## City of Albuquerque

DESIGN HYDROLOGY SECTION  
123 Central NW, Albuquerque, NM 87102  
(505) 766-7644

REF: GRADING AND DRAINAGE PLAN FOR THOMAS ELECTRIC (J14-D45) RECEIVED JANUARY 7, 1985

DRAINAGE PLAN

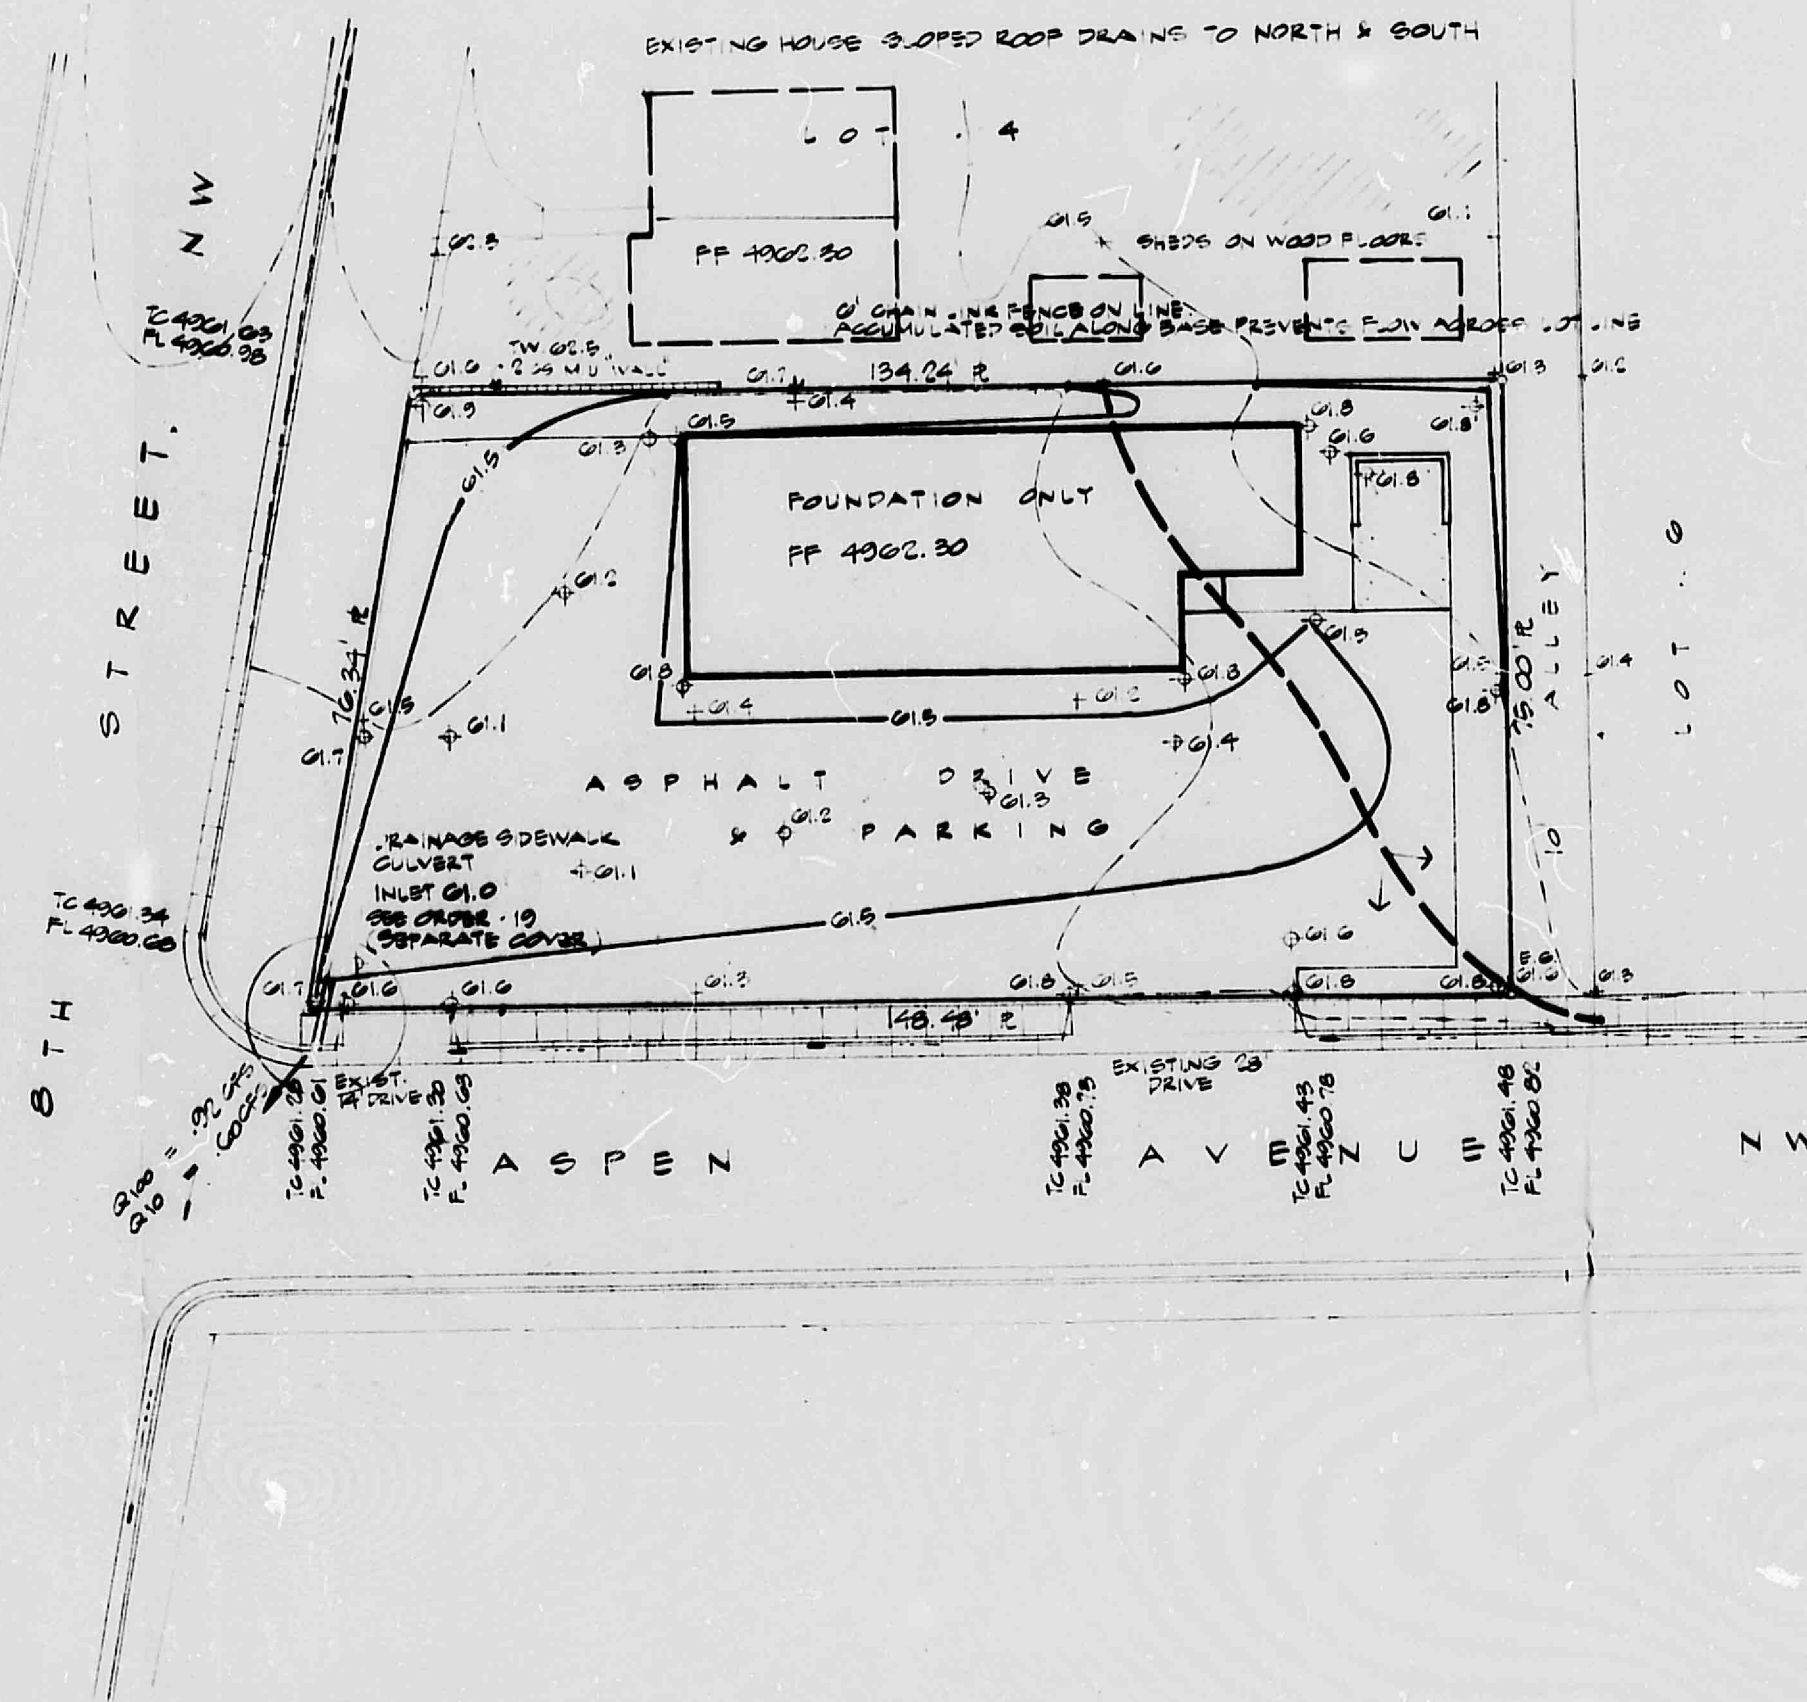
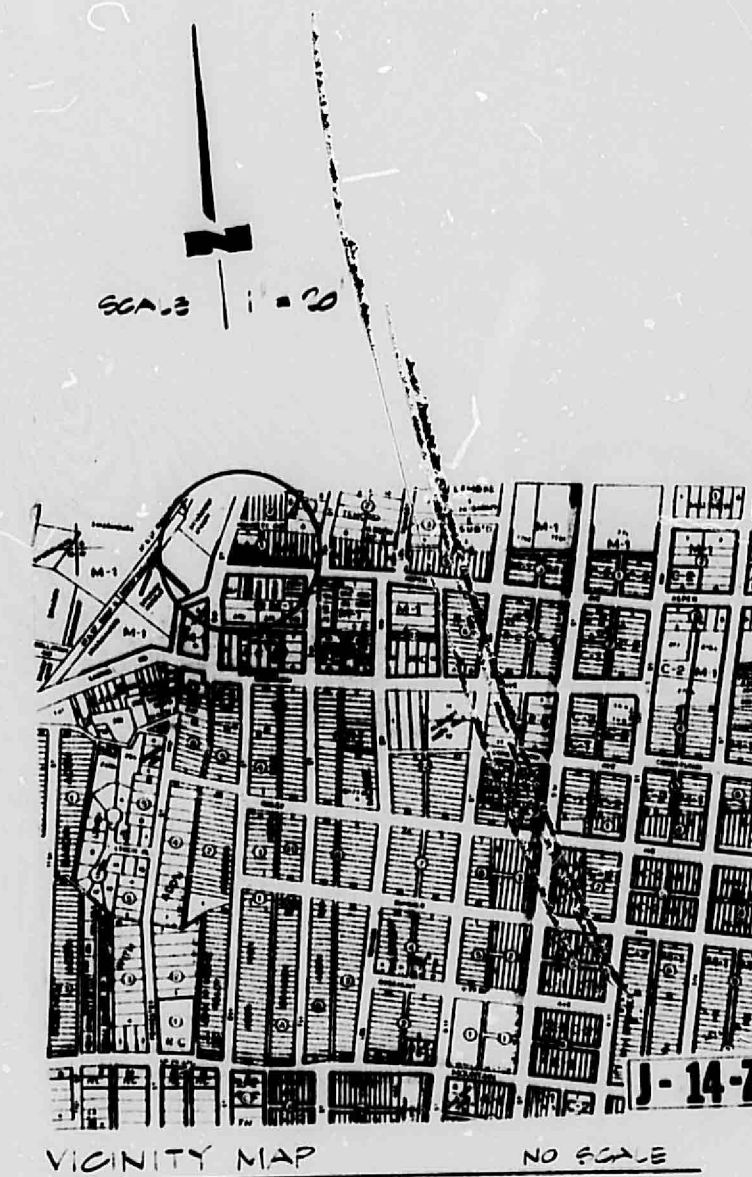
1. Based on the submittal, you are only seeking foundation approval. Generally, this approval is given while the building permit plan is in the process of review. With a foundation approval, the owner accepts all responsibilities and risks should the plan change. Therefore, if you are seeking a foundation permit I strongly recommend that a final grading plan be submitted for review prior to granting foundation approval.
2. The line shown on the plan as the division of flows is incorrect unless changes in the proposed grading are planned. The slope of the property is from the NE corner to the SW corner crossing this line.
3. City approved alley grades are required if the site is abutting an unimproved dedicated City alley.
4. Downstream capacity has not been addressed to justify free discharge.
